Notice of Modification

Section 75W of the *Environmental Planning and Assessment Act 1979*

The project approval (06_0295) for the Cadia East Project granted by the Minister for Planning on 6 January 2010.

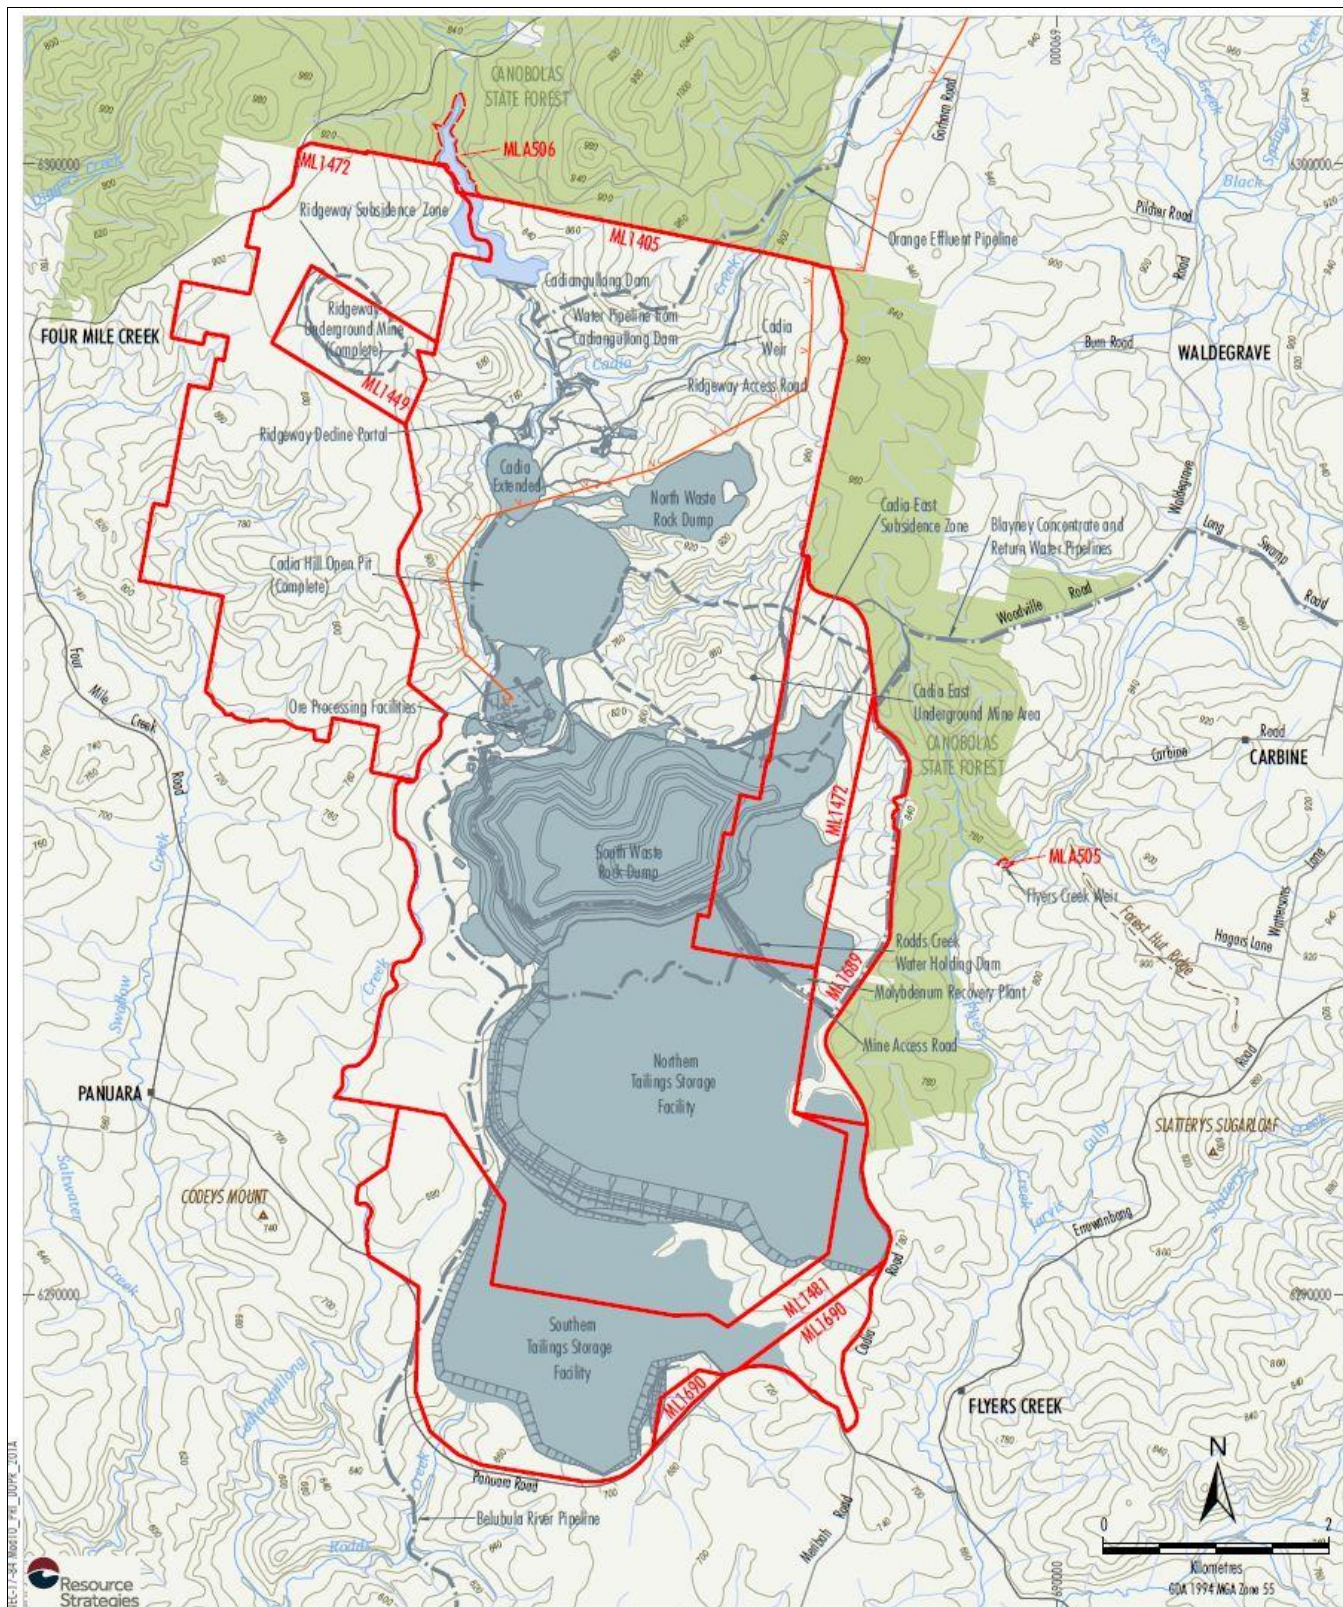
DPI Water	Department of Primary Industries – Water
-----------	--
 - In the definition for "EA", delete all words after "associated response to submissions;" and insert the following:
 - *Cadia Valley Operations Biodiversity Area Offset Modification Environmental Assessment*, dated May 2015; and
 - *Cadia Valley Operations Surface Preconditioning and On-Site Warehouse Modification Environmental Assessment*, dated February 2017.
2. Delete all references to "NOW" and insert "DPI Water".
3. In condition 41 of Schedule 3, delete the text "the Minister for Mineral Resources and".
4. Replace Figure 1 in Appendix 2 with the following:
